From: Laura Gibbons
Sent: 08 June 2018 09:52
To: Planning.Responses
Subject: RE: Please find attached amendment on planning application Ref: BR/229/17/PL

Engineers Comments Regarding Surface Water Drainage

APPLICATION BR/229/17/PL

Site Address: Land to rear of 41 - 47 Pevensey Road Bognor Regis PO21
5NY

Statement on Flood Risk and Foul / Surface Water Drainage

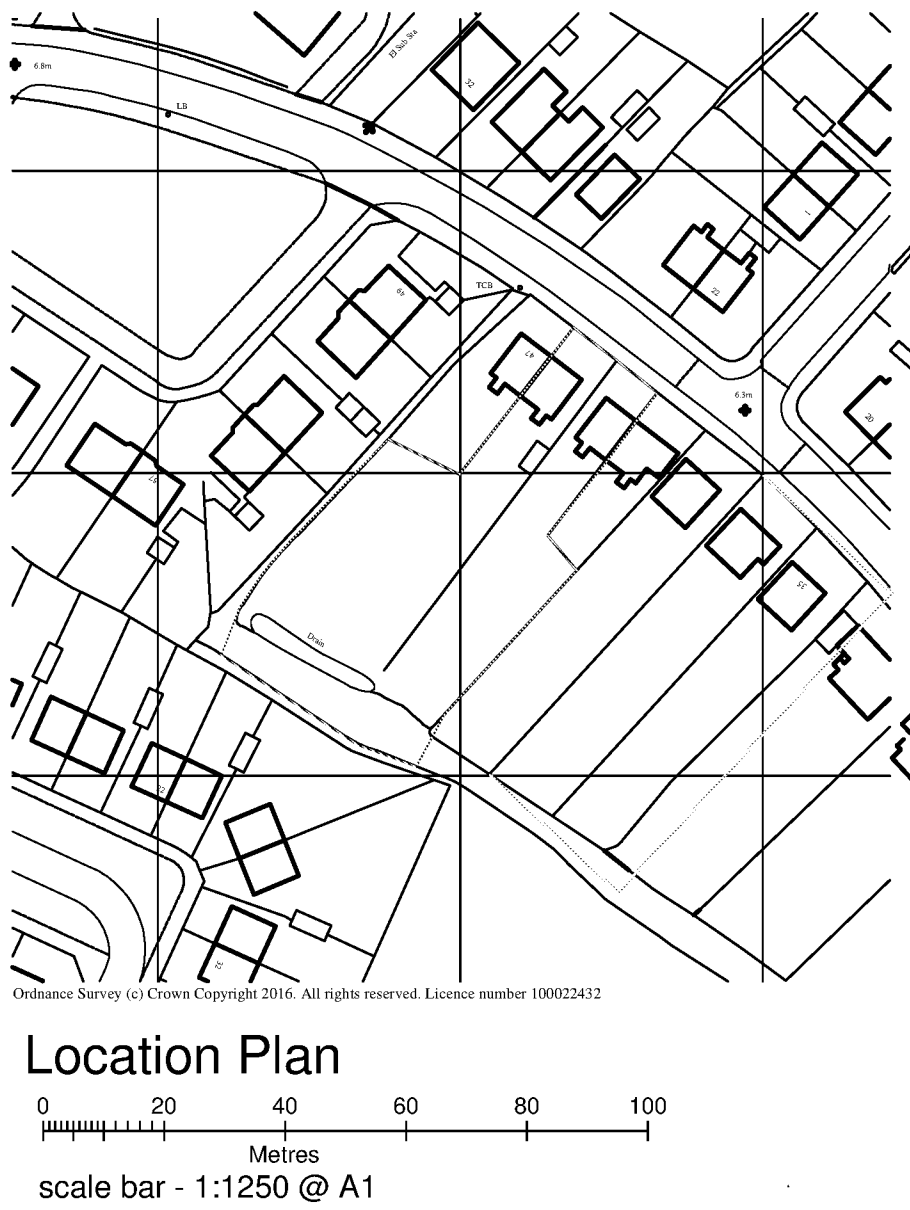
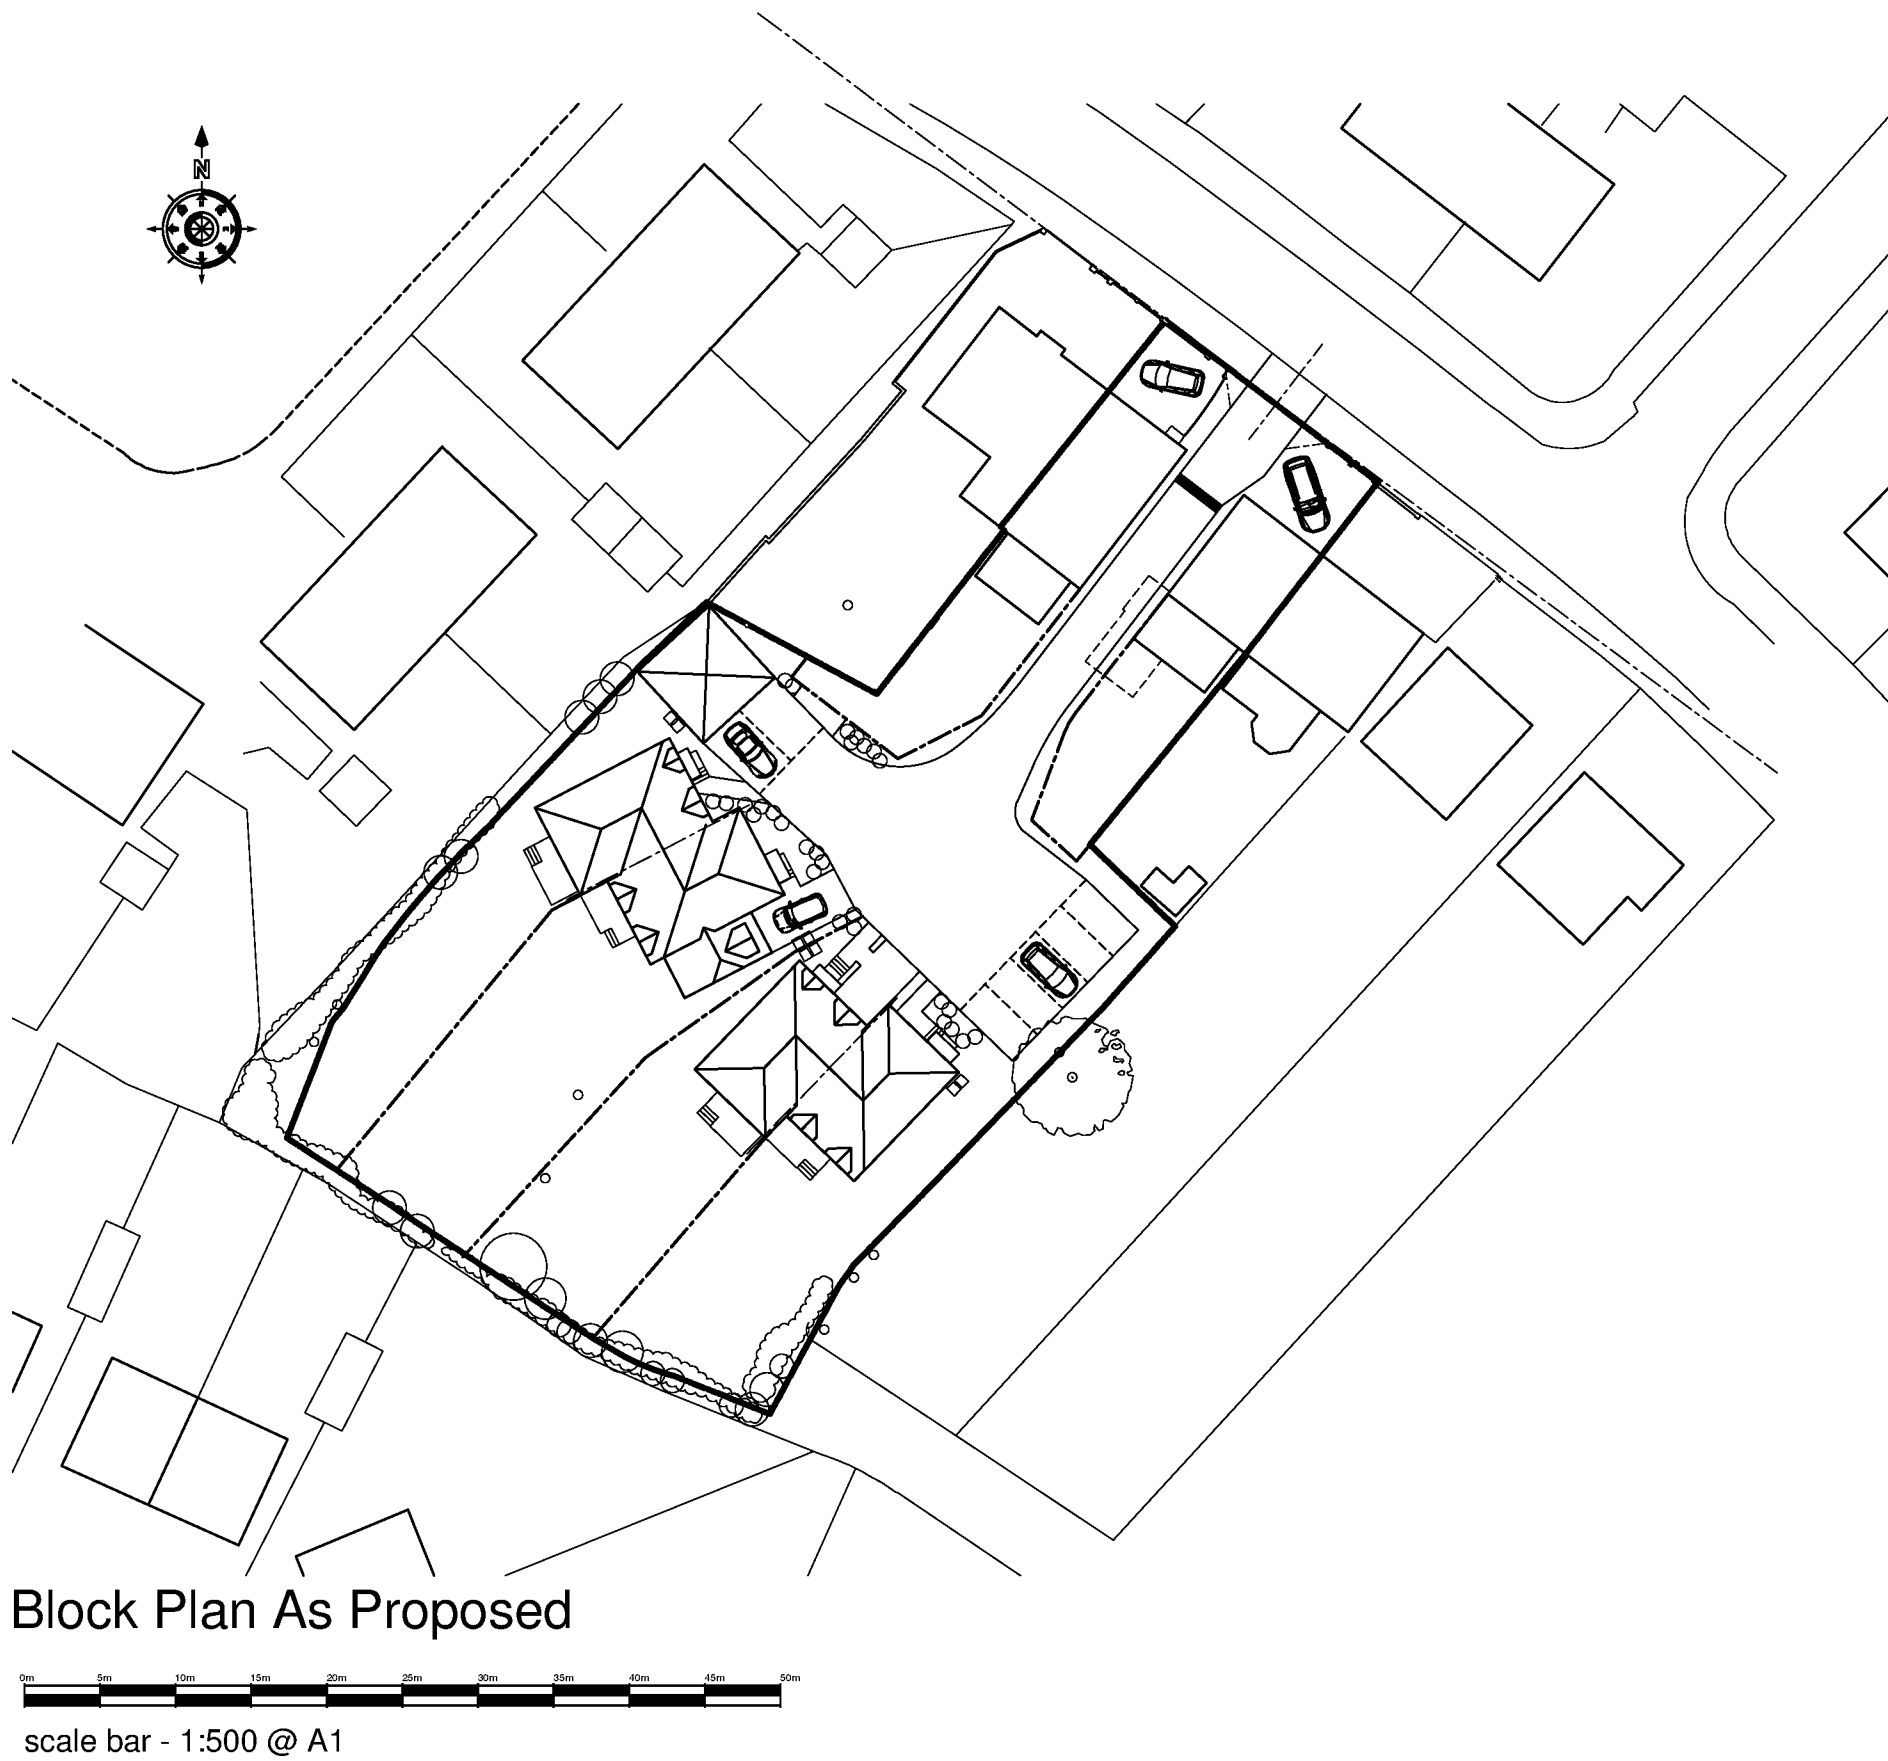
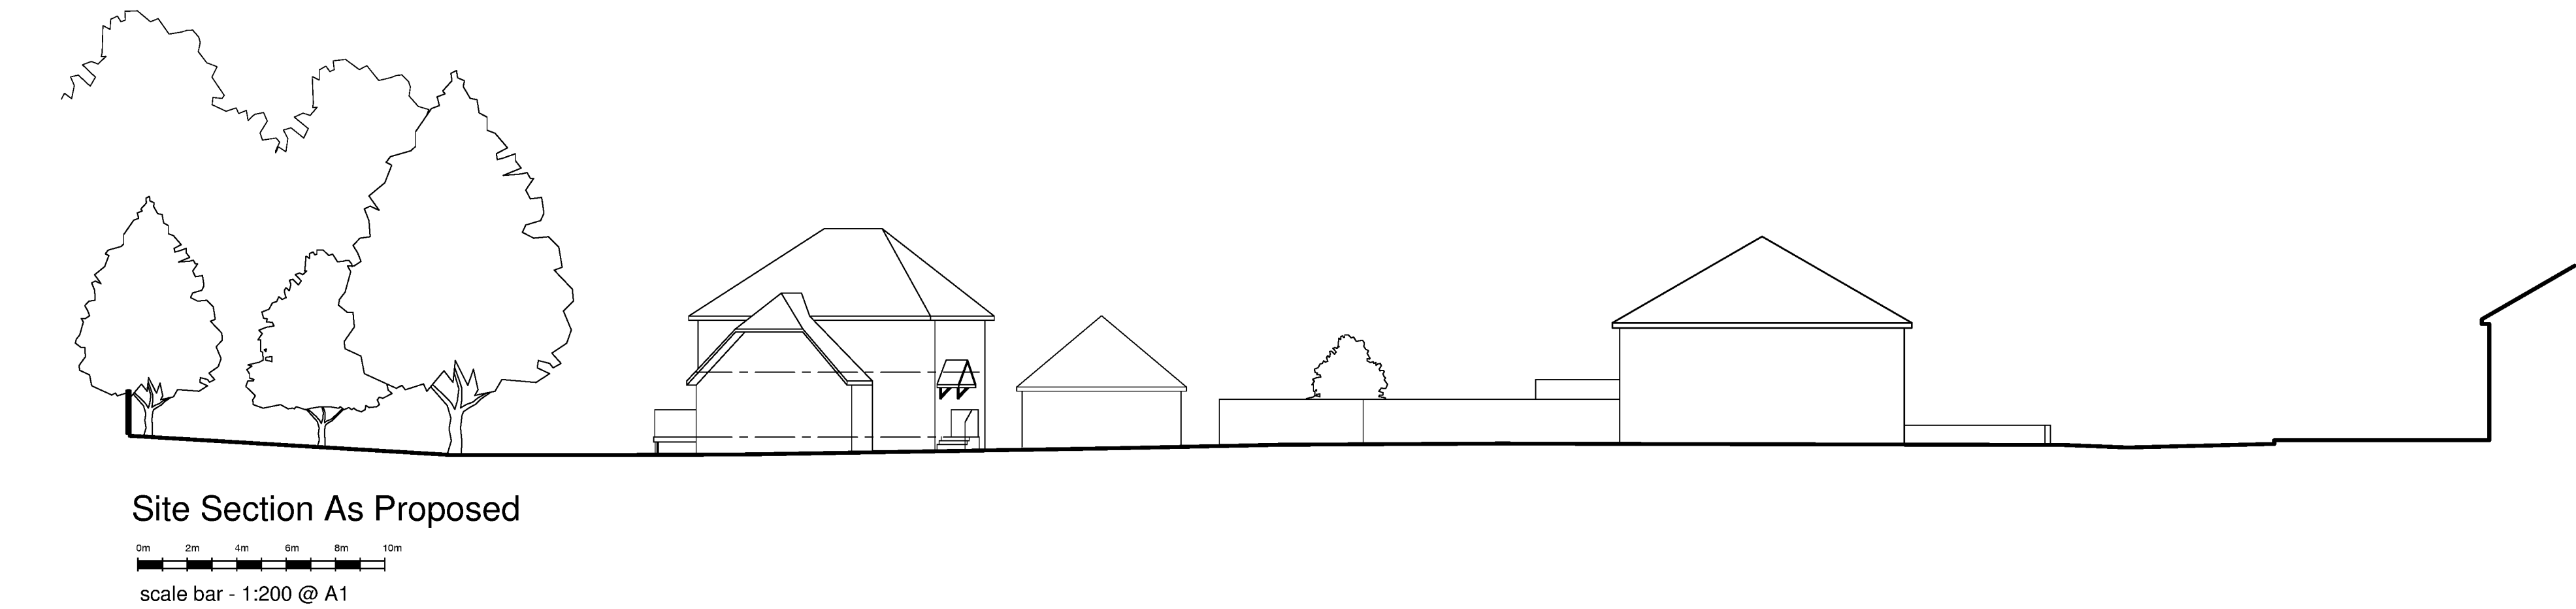
Calculations have been provided to try to demonstrate detriment will not be caused. However, we have the following concerns about the proposed approach and details provided:

1. The calculations which have been used to calculate the total volume of structures to be removed are not of adequate detail to permit sufficient checking. Please provide additional details of the existing structures, i.e. section drawings and dimensions of decking, conservatories and annex.

2. I also would like to see the volume of the garage and annexe structure reduced to just take account of walls unless sufficient evidence can be provided to show that water is currently kept out of the garage, or the foundations slab extends up to maximum flood depth.

3. More detailed is required to evidence that water will be able to get through the walls of the proposed buildings and underneath the floor. I.e. construction details. Or calculations updated to not take account of this.

4. Even if all of these calculations are correct there is insufficient compensatory storage being provided, with the total volume of new structure below flood level being 52.1m³, and the stated volume being removed 41.8m³, i.e. volume deficit of 10.295m³. The use of the permeable paving to provide this deficit would not be acceptable unless excess permeable paving is provided that is in excess of that required to drain the site.

5. A safety factor should be applied to the proposed volume to take account of future development possibilities, i.e. extensions, sheds etc. within the proposed plots.

Section AA

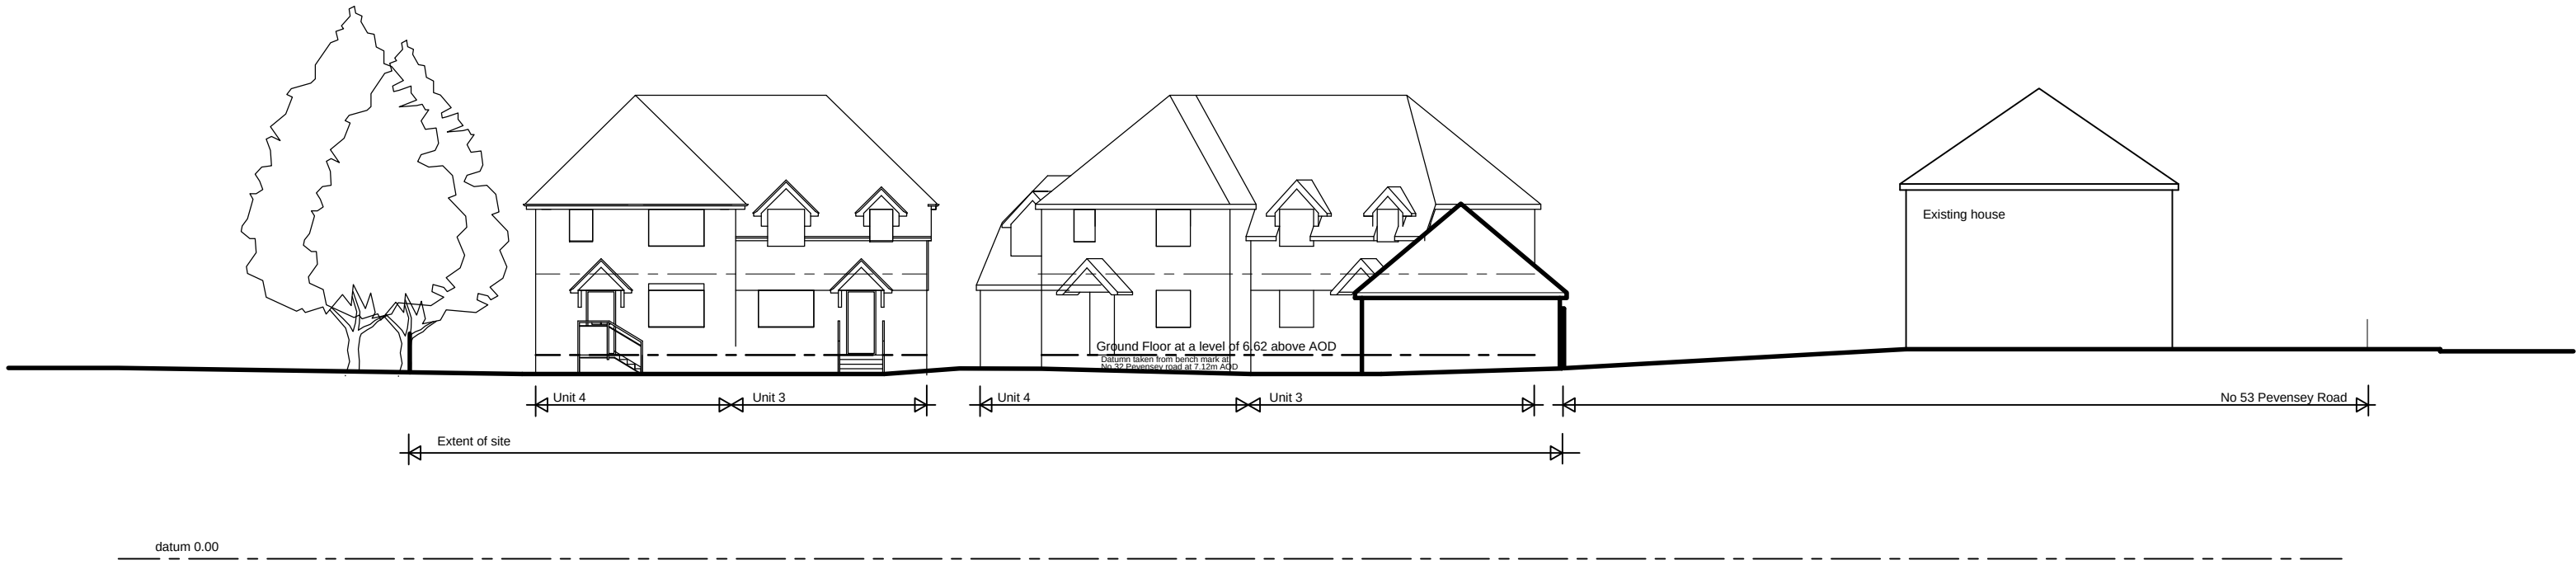
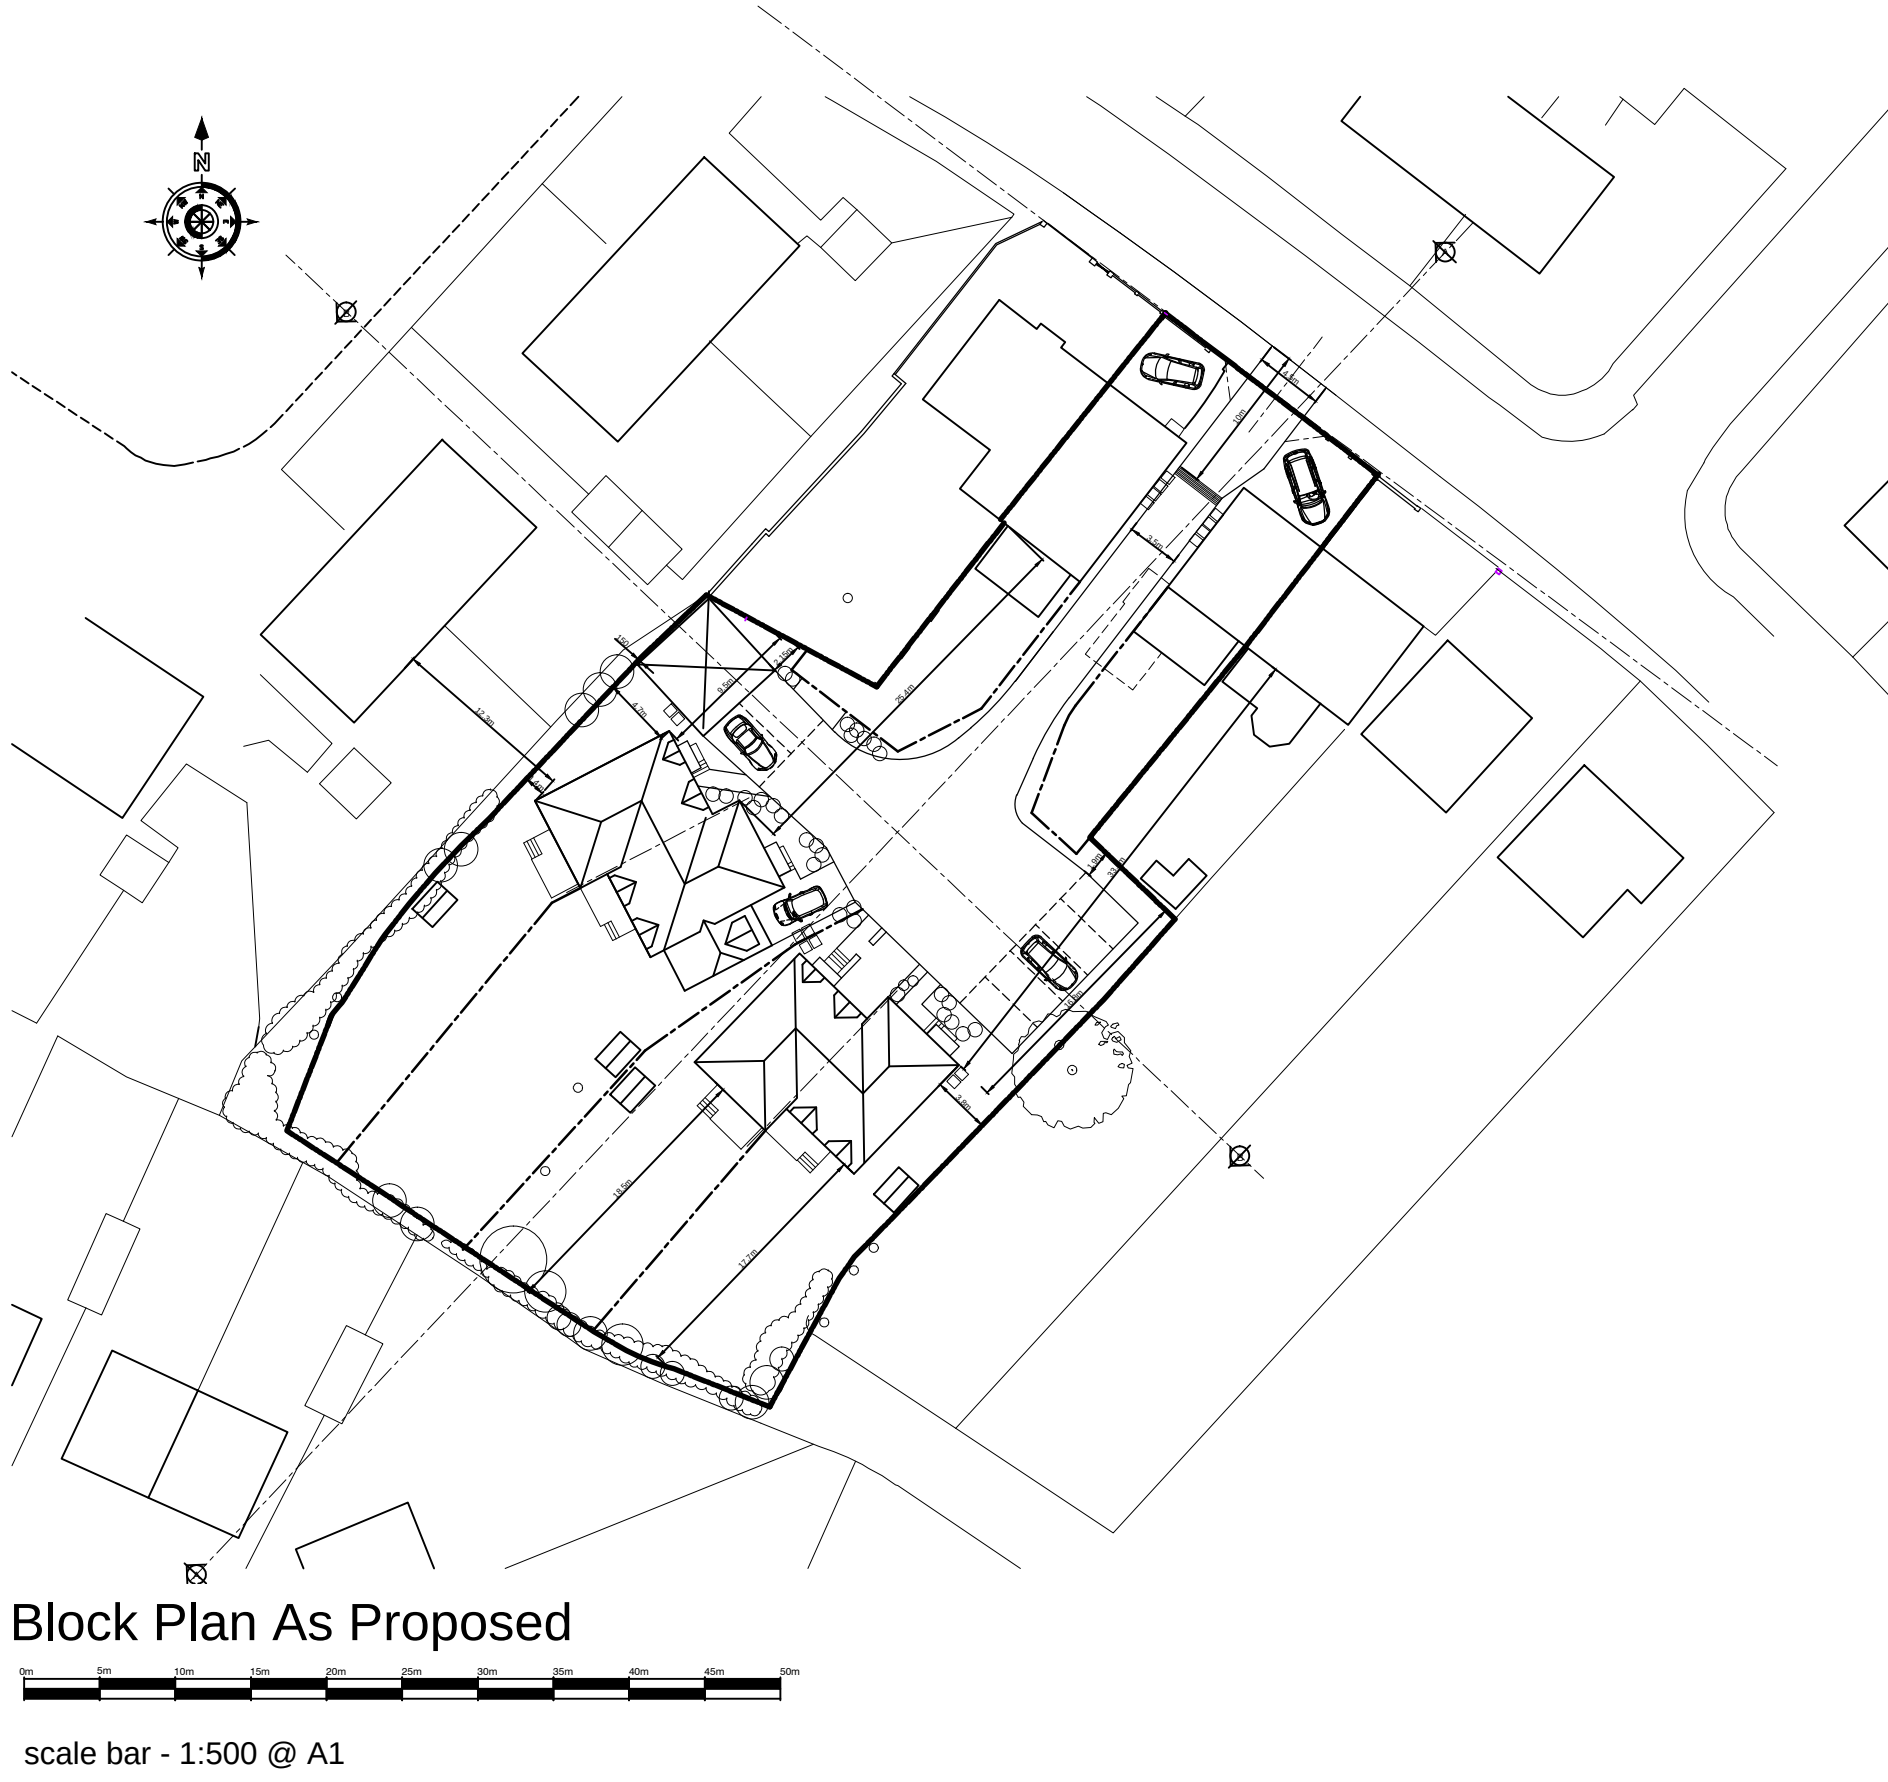
There is a level inconsistency between the existing rear gardens of number 45 and 47 Pevensey Road. We will require confirmation that no changes to ground levels are proposed as part of the development.
